Recommendation Report for Planning Permission for Works or Extension to a Dwelling

REF NO: BE/37/20/HH

LOCATION: 44 Ruskin Avenue
Bersted
Bognor Regis
PO21 5BW

PROPOSAL: Single storey front & rear extensions.

PROPOSED
GROUND FLOOR PLAN
1-100

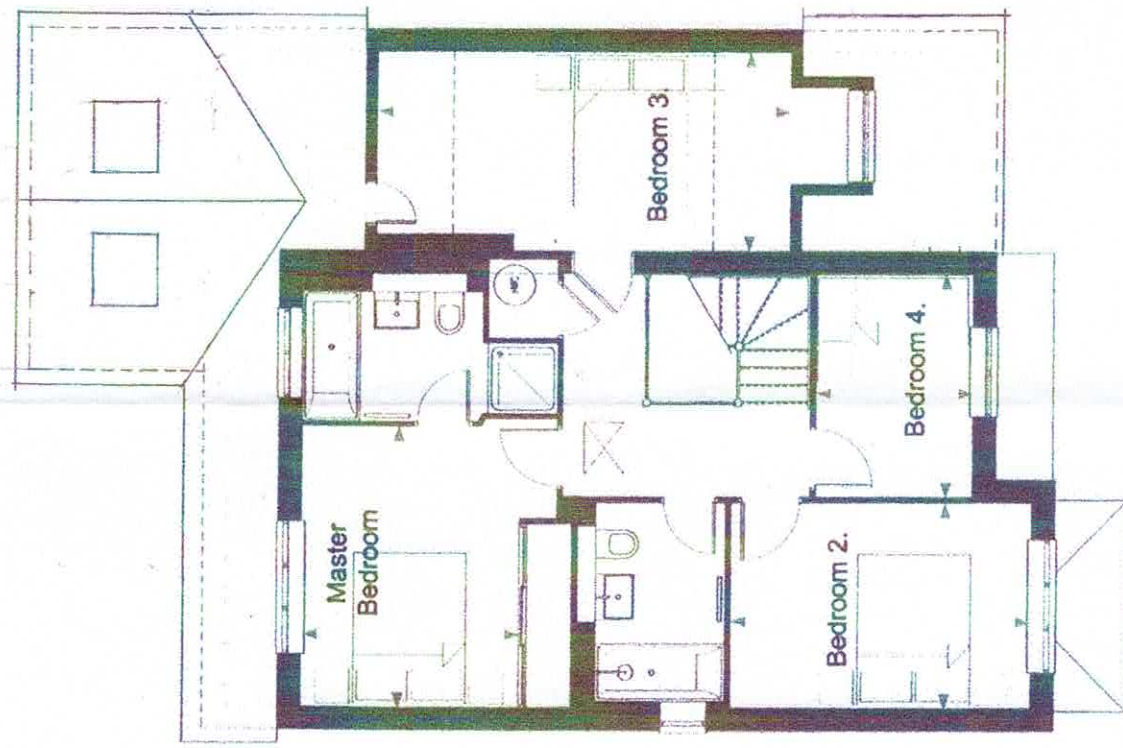
The front extension has a depth of 1m and width of 2.9m to run in line with the of the existing principle elevation. This does not extend beyond the front elevation and as such is not considered to appear unduly dominant upon the street scene.

The extension to the front of the property retains approximately 5.4m to the northern boundary. This will have a flat roof with a height of 2.3m to match that of the existing eaves on the property. Due to the siting to the front, it is not considered to give rise to adverse impacts upon neighbouring amenity

To the rear the proposal leaves 7.6m to the southern boundary. With the development being single story there is no overlooking or overbearing impact. There will be 1.2m to the boundary to the north-west with a pitch that leans away from the boundary ensuring there is not an unacceptable level of overbearing or overshadowing.

PROPOSED
Front Elevation.
1-100

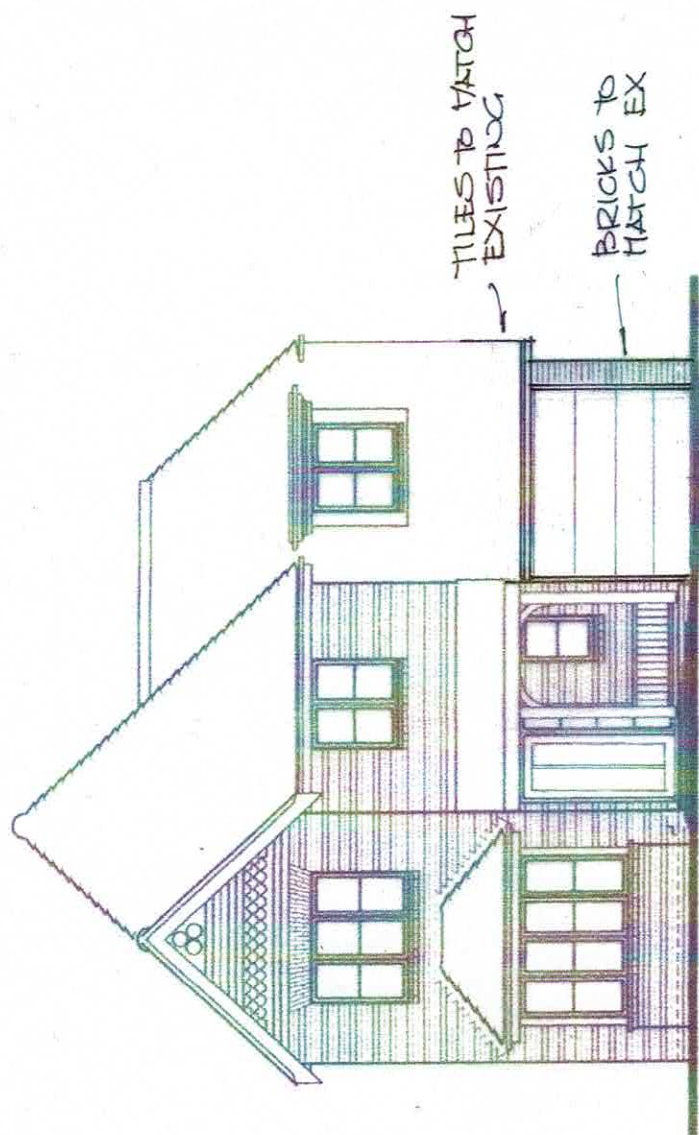
The proposal will construct an extension to the front of the property and as such it is visible from the street scene however the works are sympathetic with the garage having no materially different frontage.

PROPOSED
Rear Elevation.
1-100

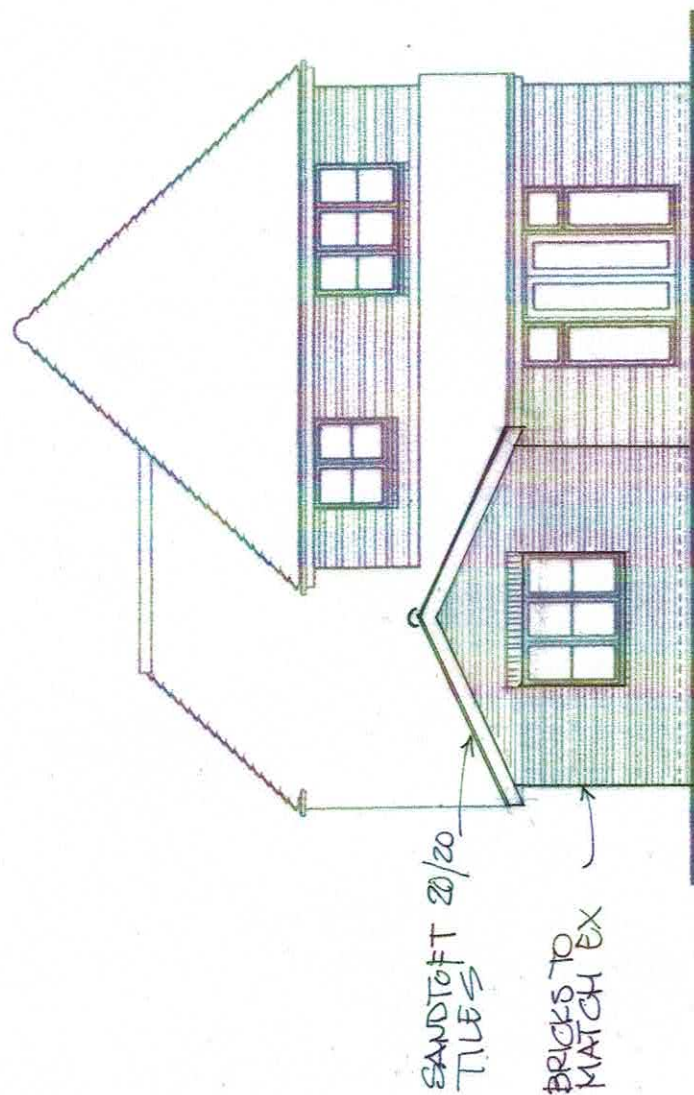
The rear extension has a height of around 3.7m at pitch and 2.4m at the eaves. Due to the siting of the neighbouring property to the south and with a garage at the boundary, the extension is not considered to give rise to adverse impacts.

There will be glazed doors to the rear however with the development at single storey, views are not considered to increase from that which is already available. There will also be an additional rooflights to the rear extension which are not considered to cause overlooking due to their location.
